**Consultation Response from KC,
Highways Development Management**

2025/92139 The Old Dewsbury Library, Wellington Road, Dewsbury, WF13 1HN

**Alterations to former library to form 14 apartments with associated internal and external works
(Listed Building within a Conservation Area)**

Date Responded: 31/03/2026

PROPOSED BLOCK PLAN
1:500

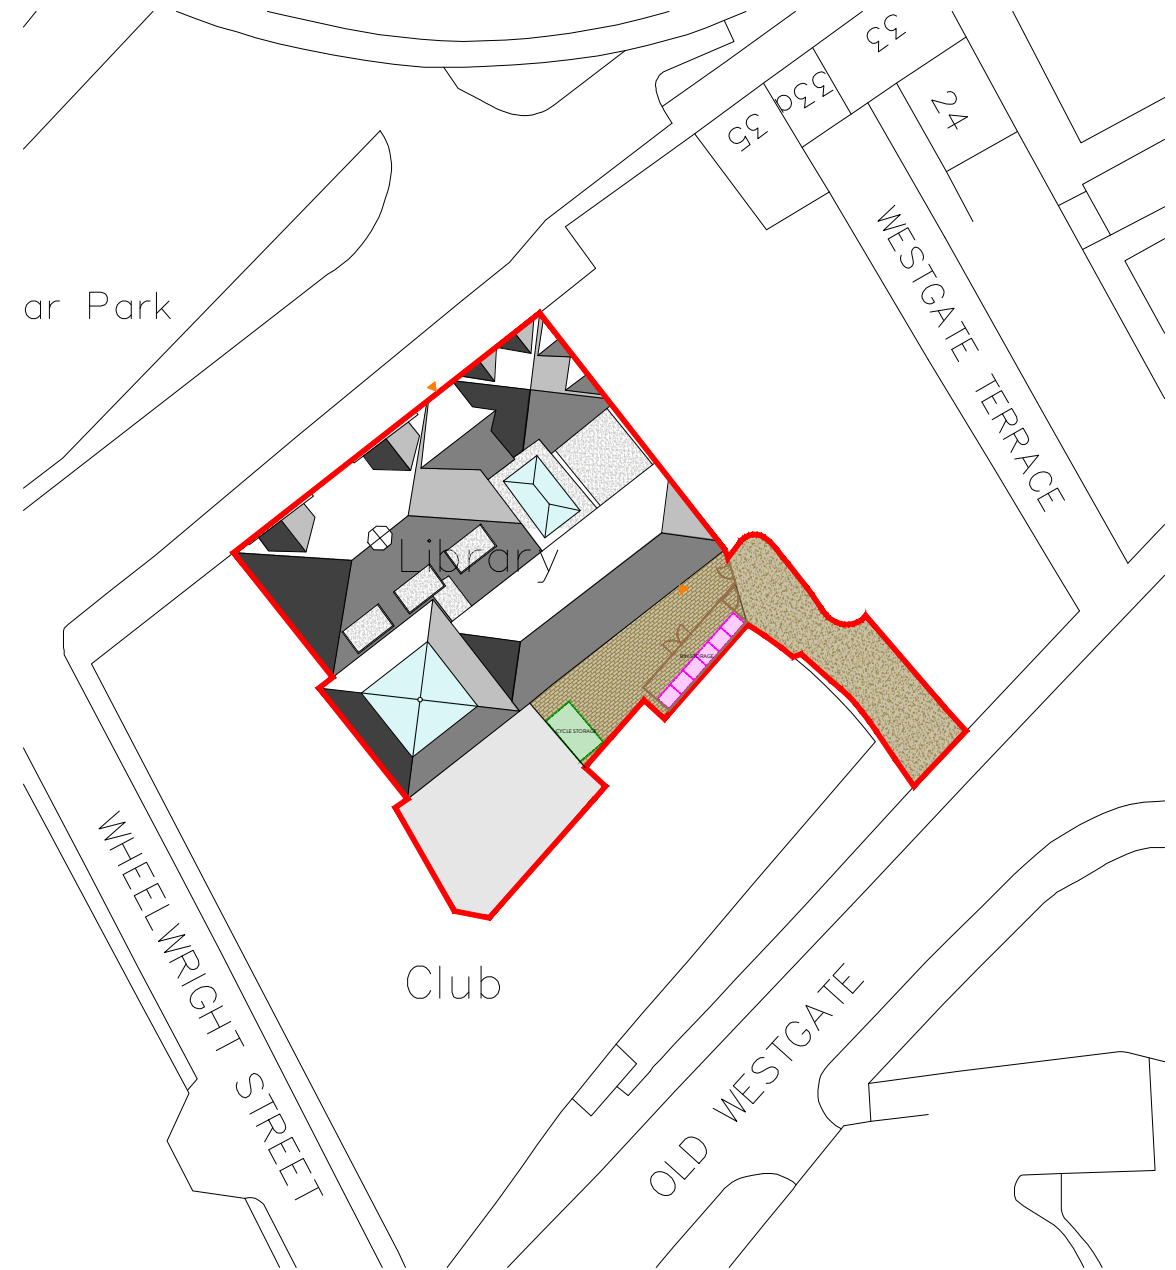
No bin store and/or bin collection/presentation is shown on the proposed plans.

A bin collection/presentation point should be located adjacent to the public highway and must not obstruct the adopted highway or access.

Details of the waste collection for the proposals should be provided, with the location of a waste collection presentation point being clearly marked on a drawing in such a location that is easily accessible to the collection team and where it will not obstruct the access or the adopted highway for road safety reasons.
